From: Wayne Frisk <waynendeb@gmail.com>
Sent: Friday, April 17, 2026 12:29 PM
To: Bradley Gasawski
Subject: Easton Travel Center SE-26-00001

Re: SEPA Comments – Proposed #SE-26-00001 Easton Travel Center

In reviewing the SEPA Checklist filed with CDS on 4-1-2026, there are numerous responses which are either not descriptive enough in the project proposal to assess the actual impact, and/or the responses submitted lack sufficient detail to address the following concerns:

SCALE GRAPHIC	EASTON TRAVEL CENTER	SHEET
DRAWN BY: LVE	PARCEL SITE PLAN	1
CHECKED BY: LVE	EASTON, WA	
SURVEYED BY:	DATE: FEBRUARY 13, 2024

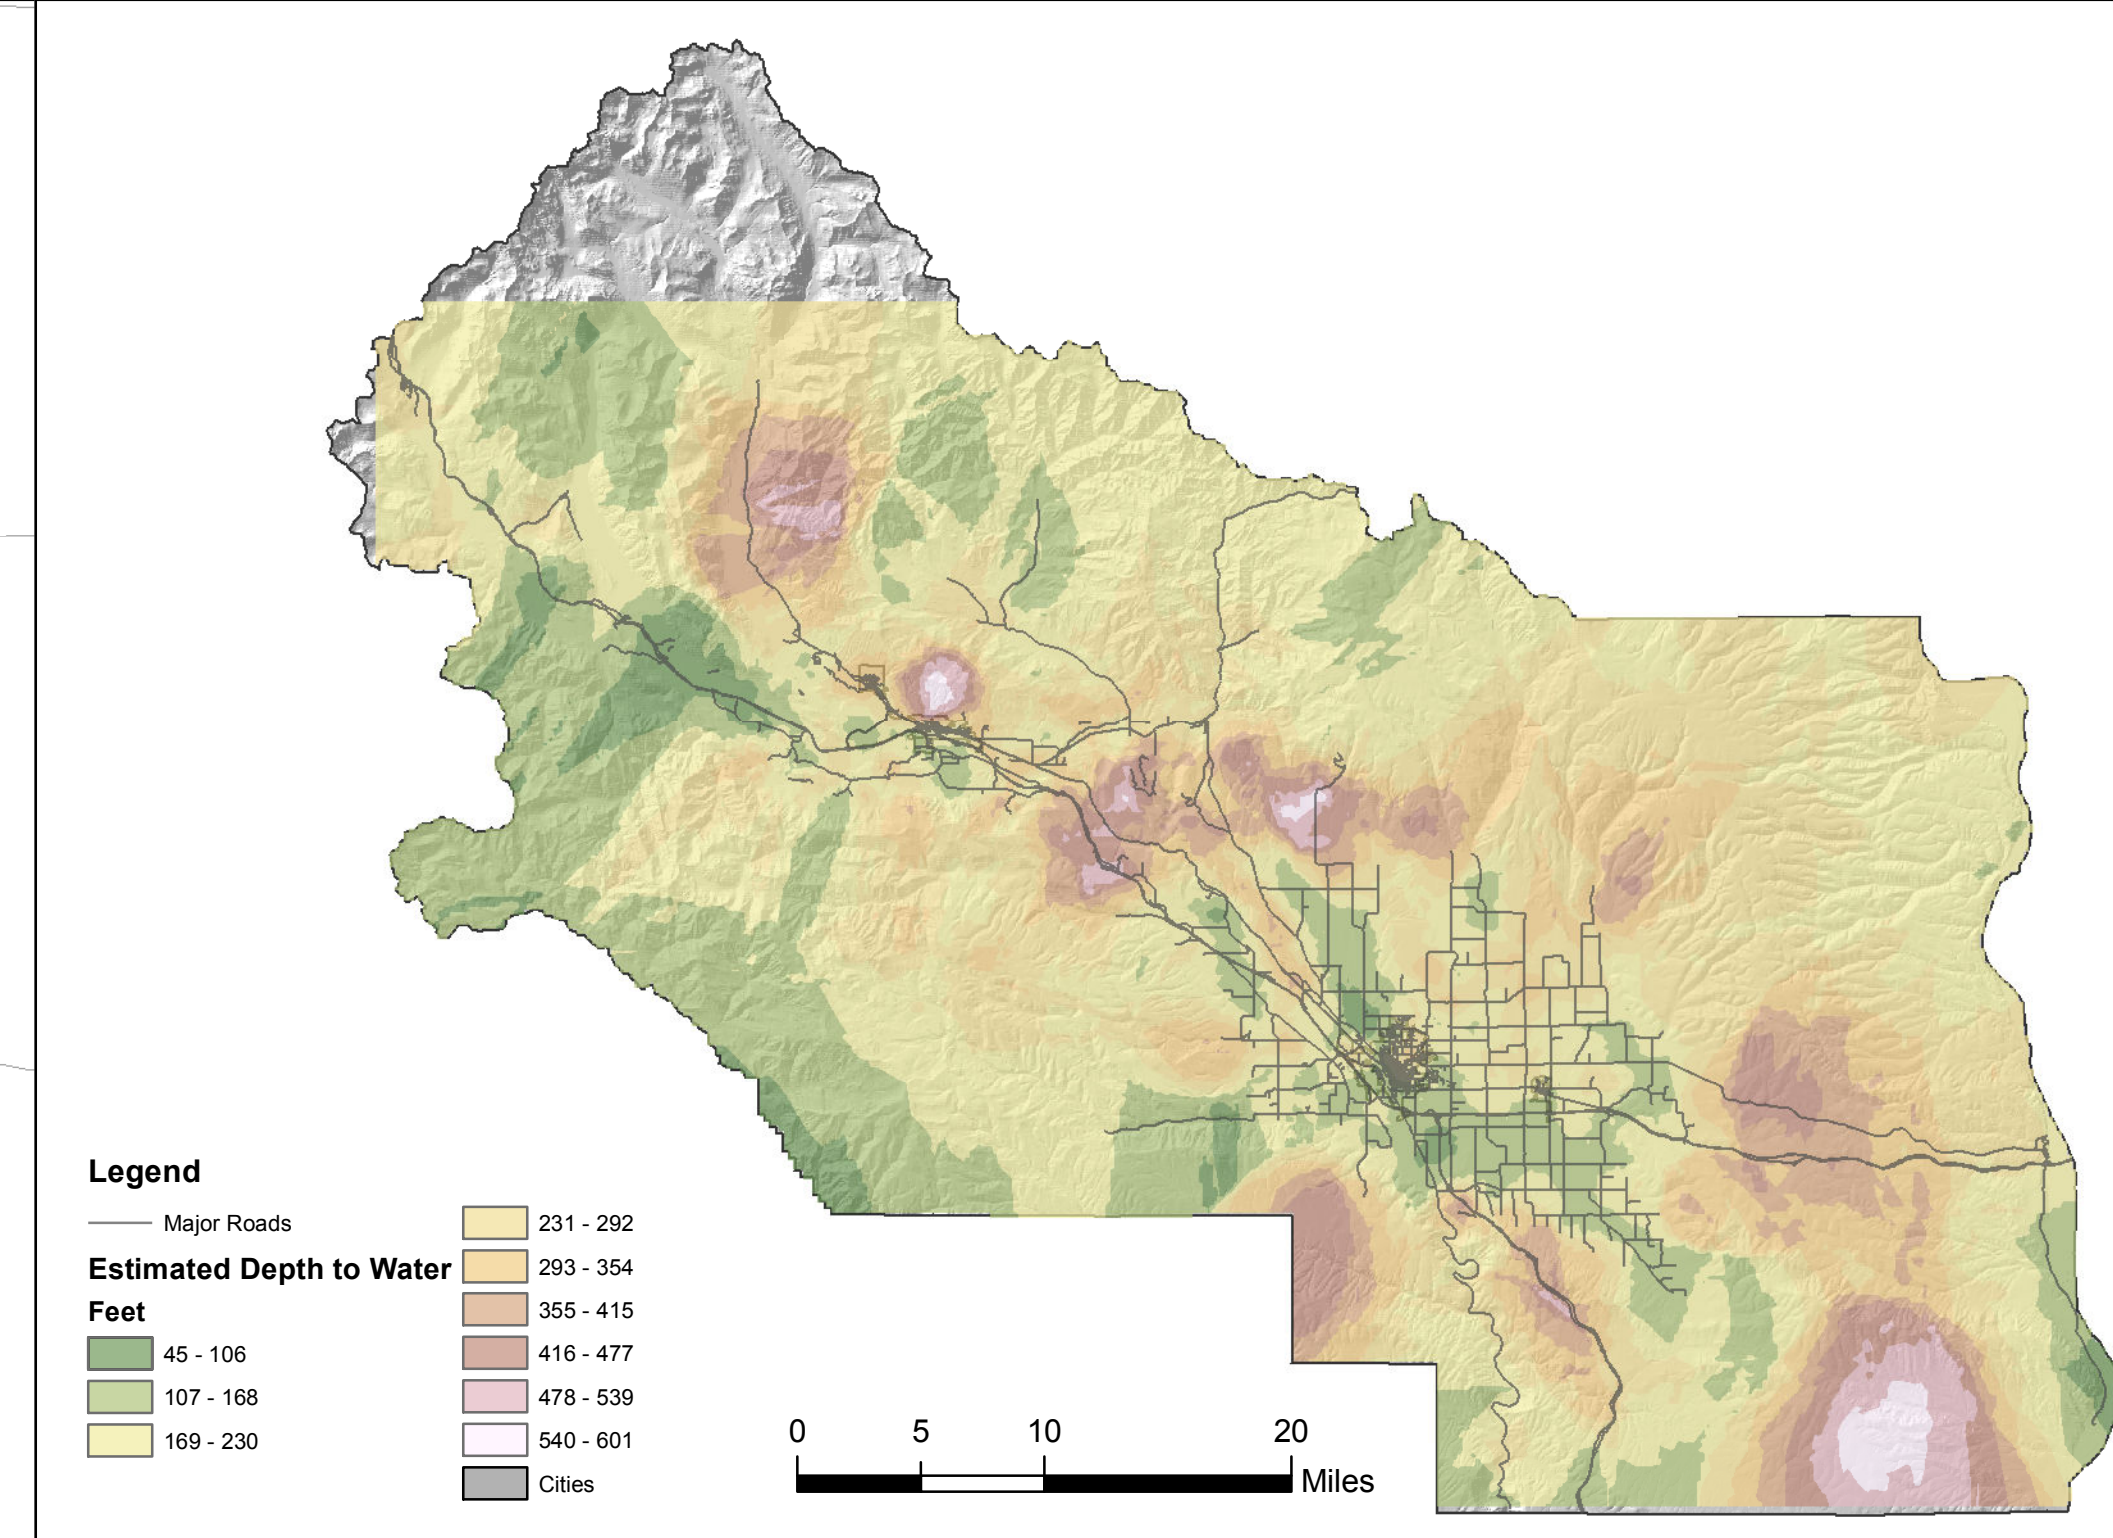
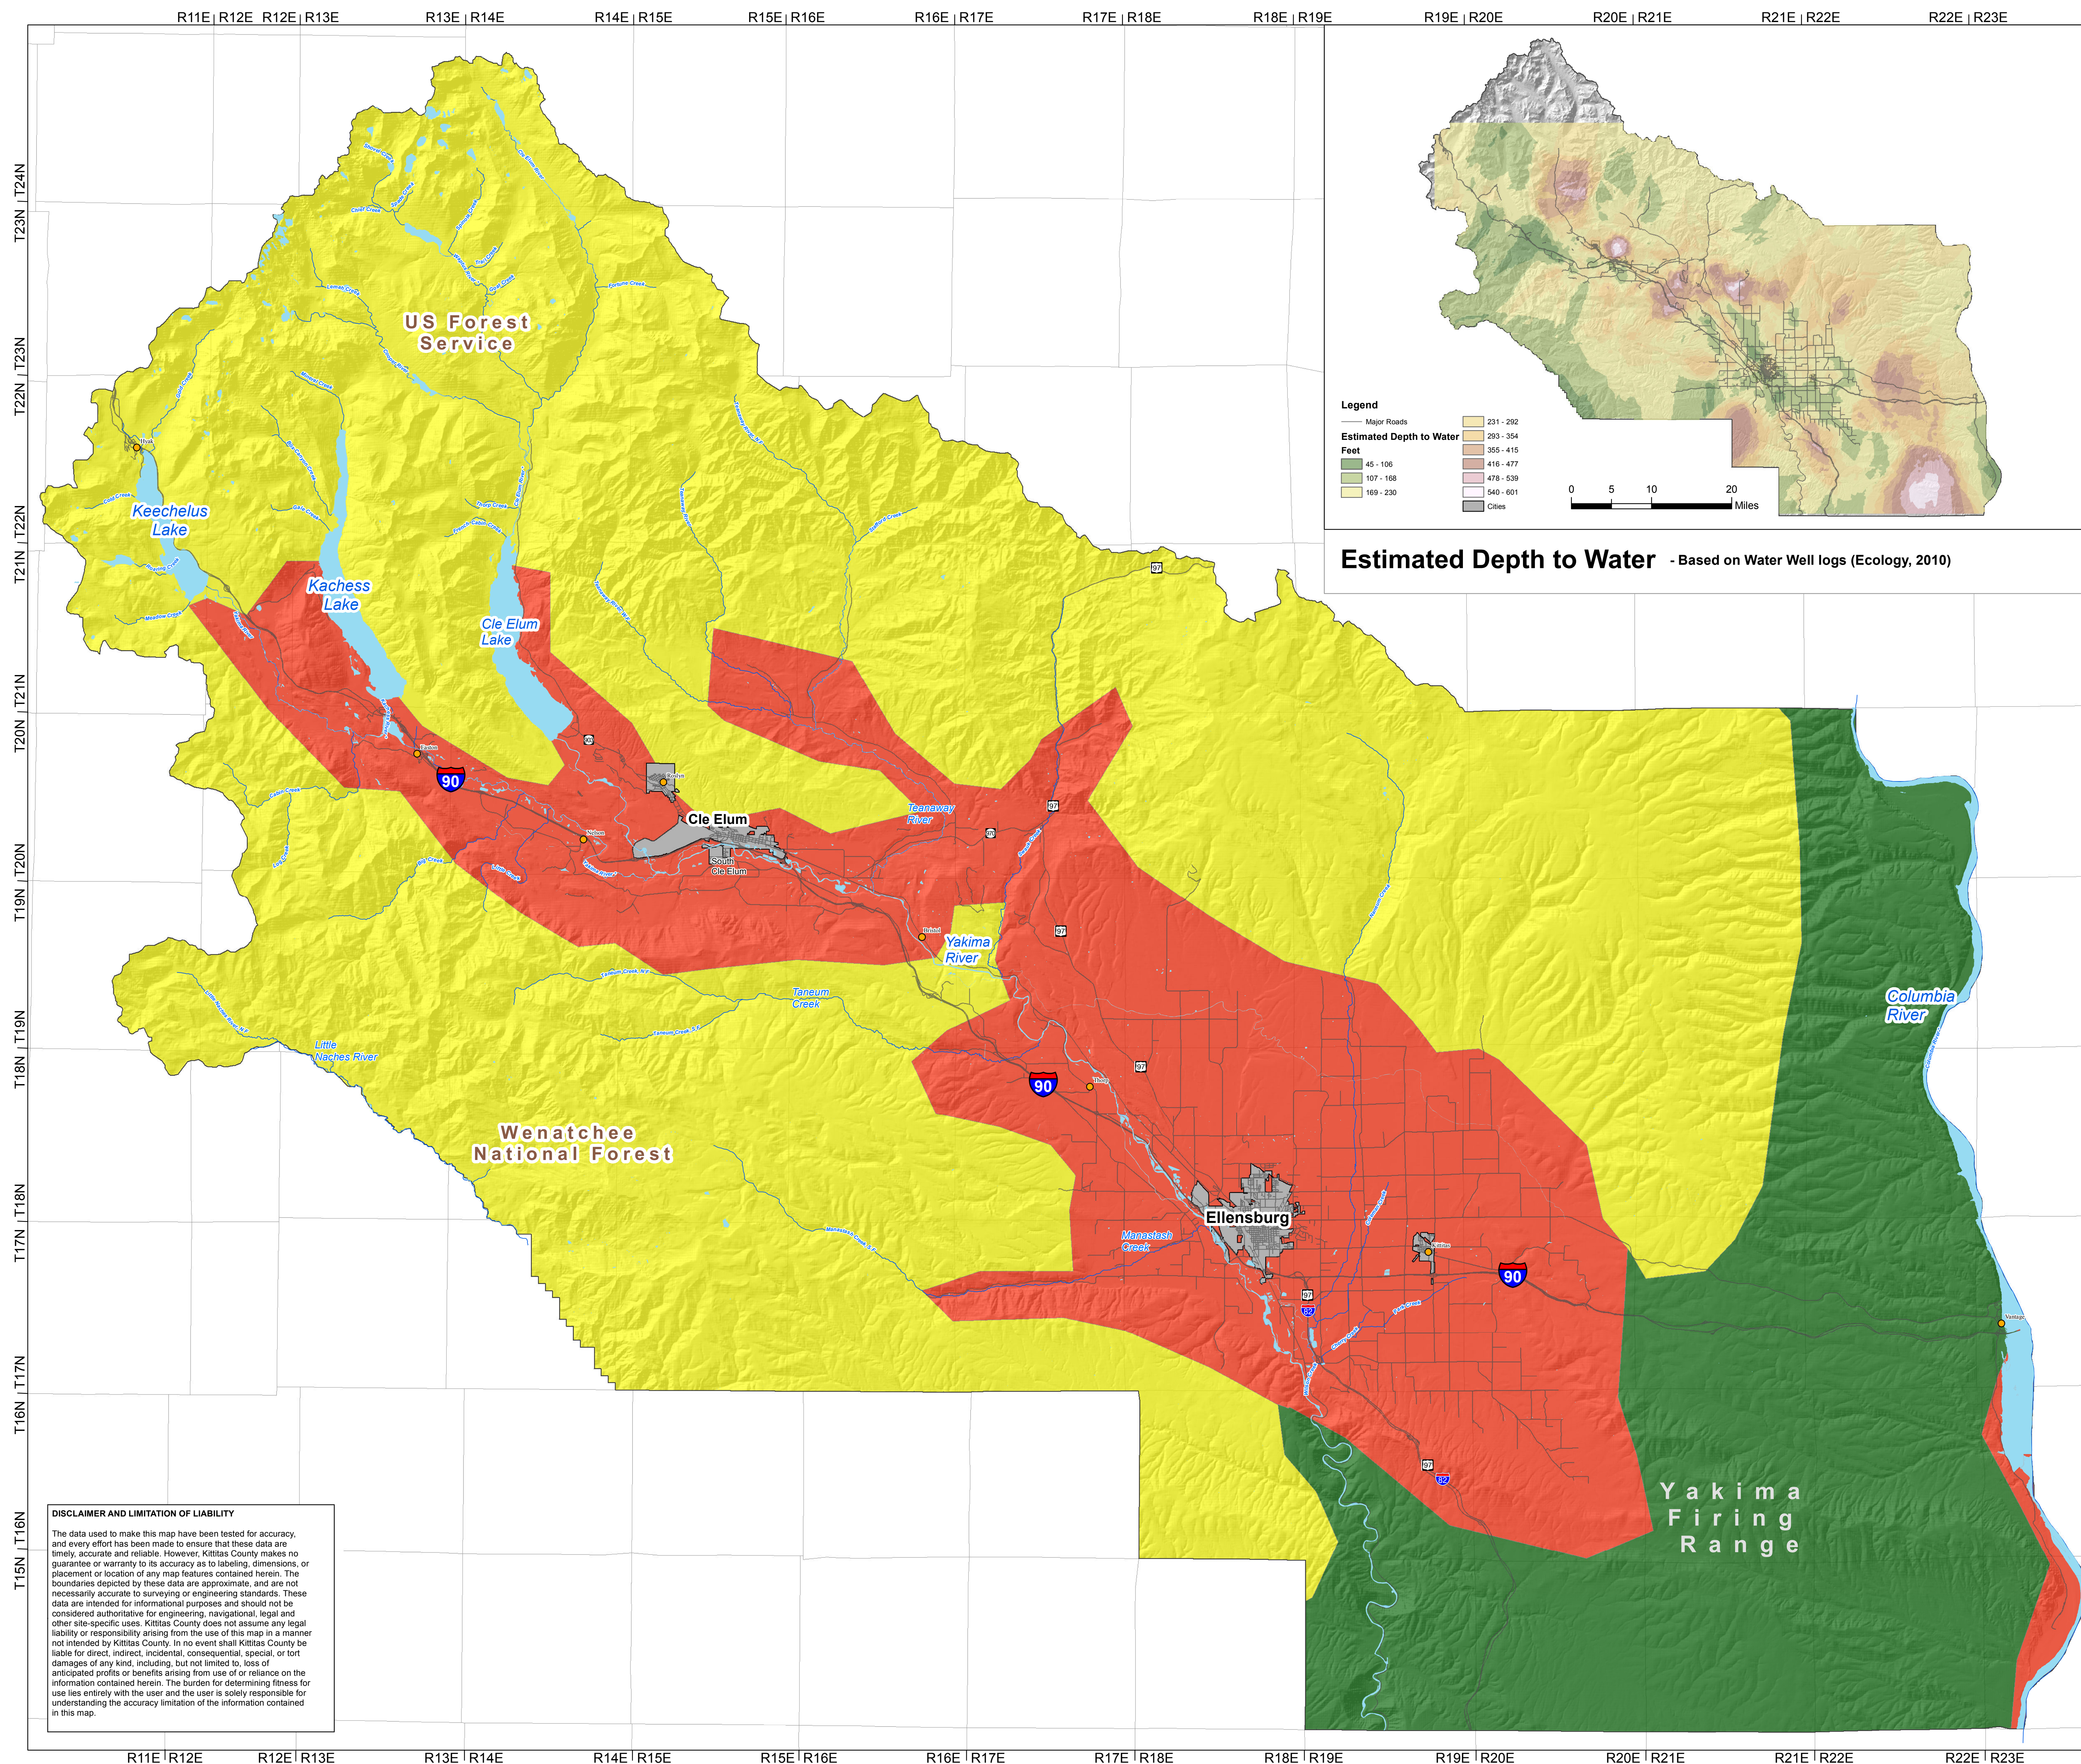
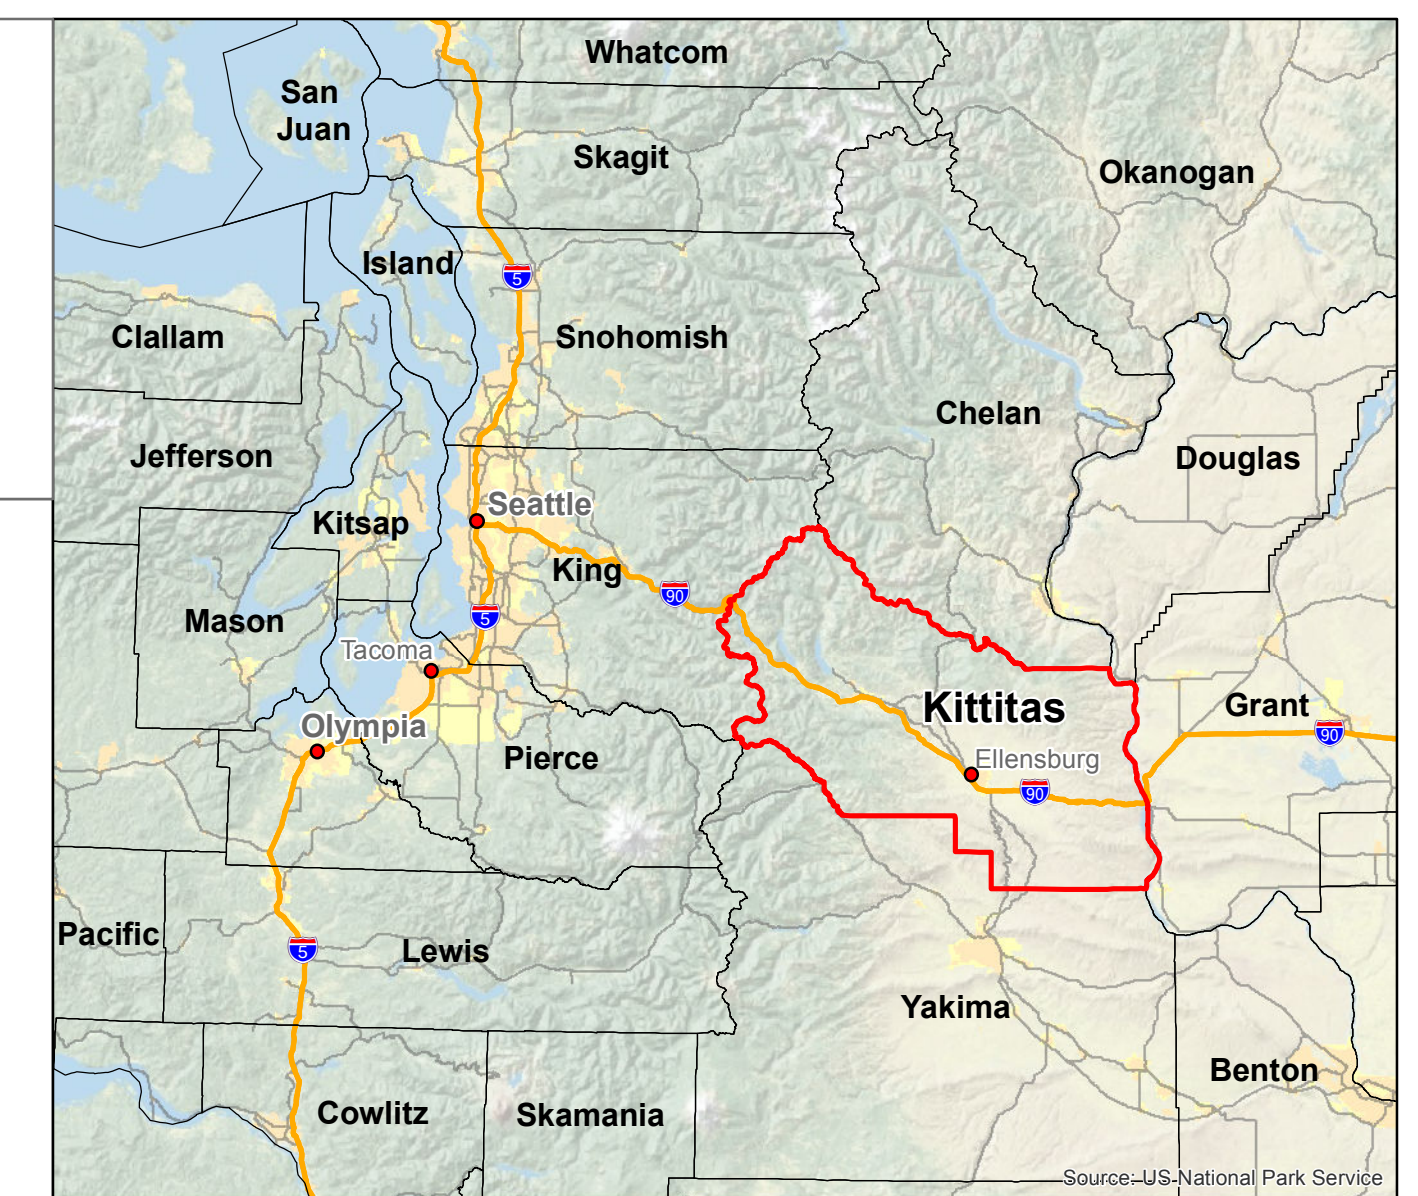
Regarding snow, I was unable to find any reference to a detailed snow removal and storage plan. Facilities of this type will be removing snow contaminated with petroleum-based products, or worse, hazardous products from leaking trucks and cargo containers. If the snow is not treated as runoff and stored on impervious surfaces with proper best management practices, the potential for groundwater contamination is greatly increased. I fail to see where adequate storage exists on the site plan.

The submitted SEPA Checklist and inadequate project description fails to specify the volume of impervious surfaces (such as the large parking aprons necessary for commercial vehicles both in fueling as well as overnighting) anticipated at the site, other than it will not exceed 33%.
